Application No: FP/212/20/OUT
Site Address: Pipers Croft 6 The Loop Felpham PO22 7ND
Description of works: Outline application with all matters reserved for 1 No. 4 bed detached dwelling.

Thank you for your internet representation made on 22nd November 2020 which has been recorded as an objection with the comments as follows:

Dear Ms Tomalova,
Ref: Planning Application FP/212/20/OUT - 6 The Loop
I have the following objections:

Block Plan

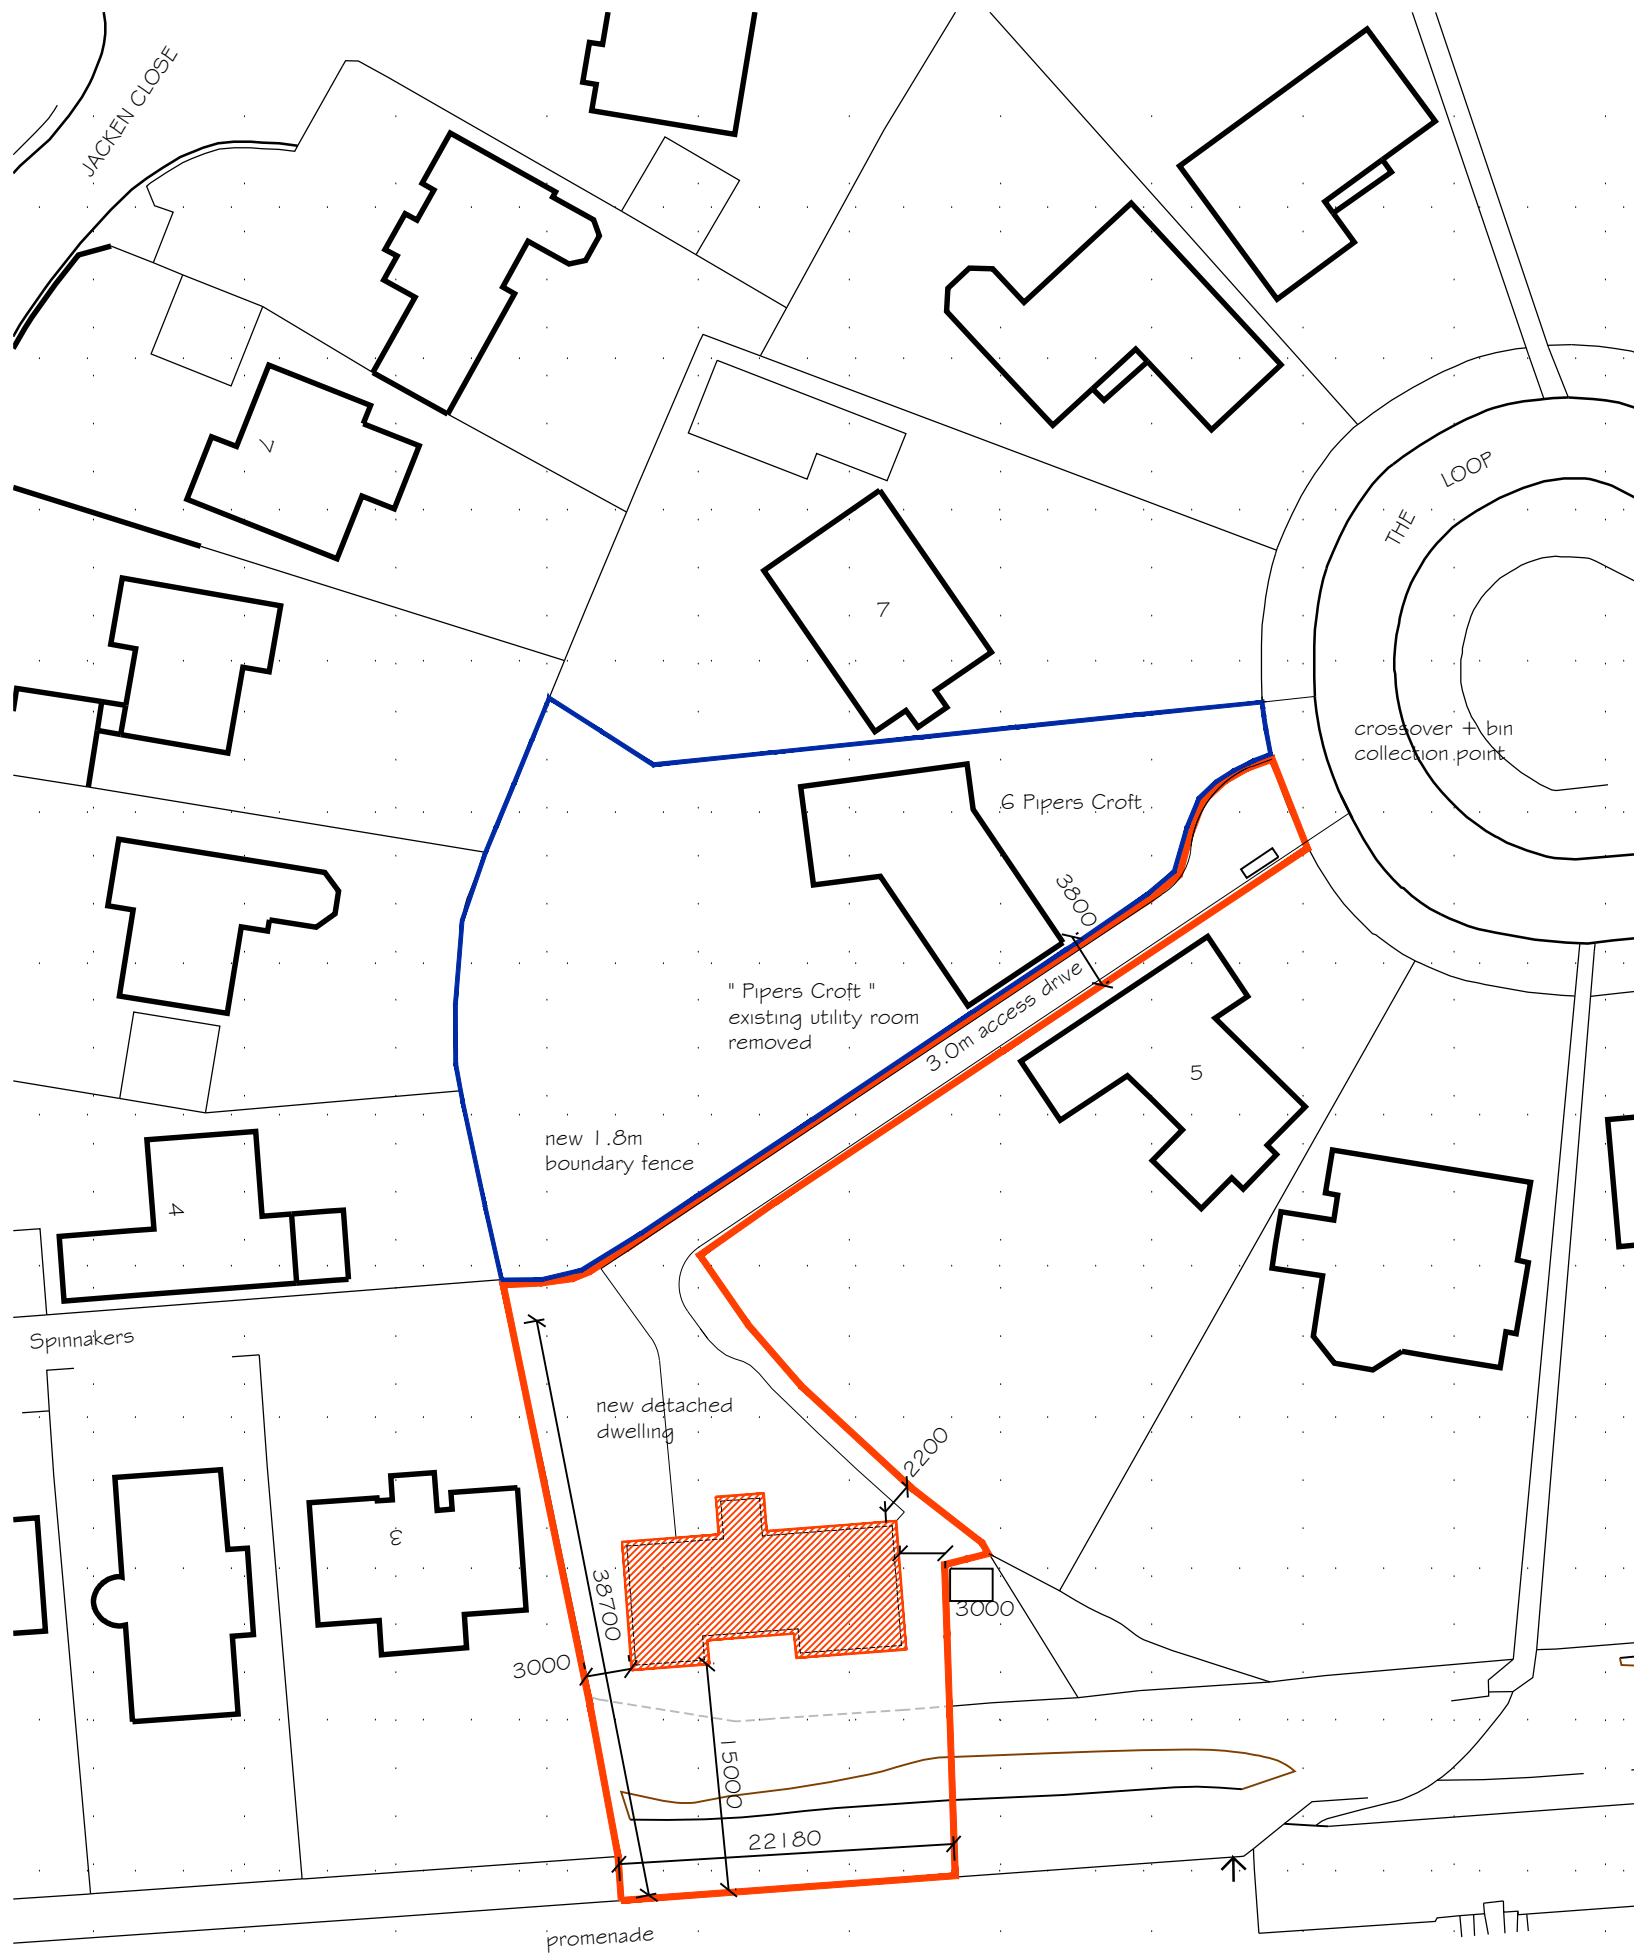
4. The proposed new driveway is alongside and extremely close to No 5 The Loop and is not wide enough for cranes and building machinery, let alone for emergency vehicles thereafter. No 5 will be hugely noise polluted with any construction work and by the new incumbents living there, should it, wrongly, be given the go ahead. All the houses on the Loop have been designed to have their driveways at the front of their properties, thus, currently, minimally affecting their neighbours.

8. I note from the plan that the proposed development appears to extend to the Promenade. I question whether this is correct as it incorporates a raised Sea Defence Bund. I would suggest that any interference with the Bund could jeopardise Life, in so far as its prime purpose, as its name implies, is to defend against incoming seas. In this era of climate change and rising sea levels, it is more important than ever.
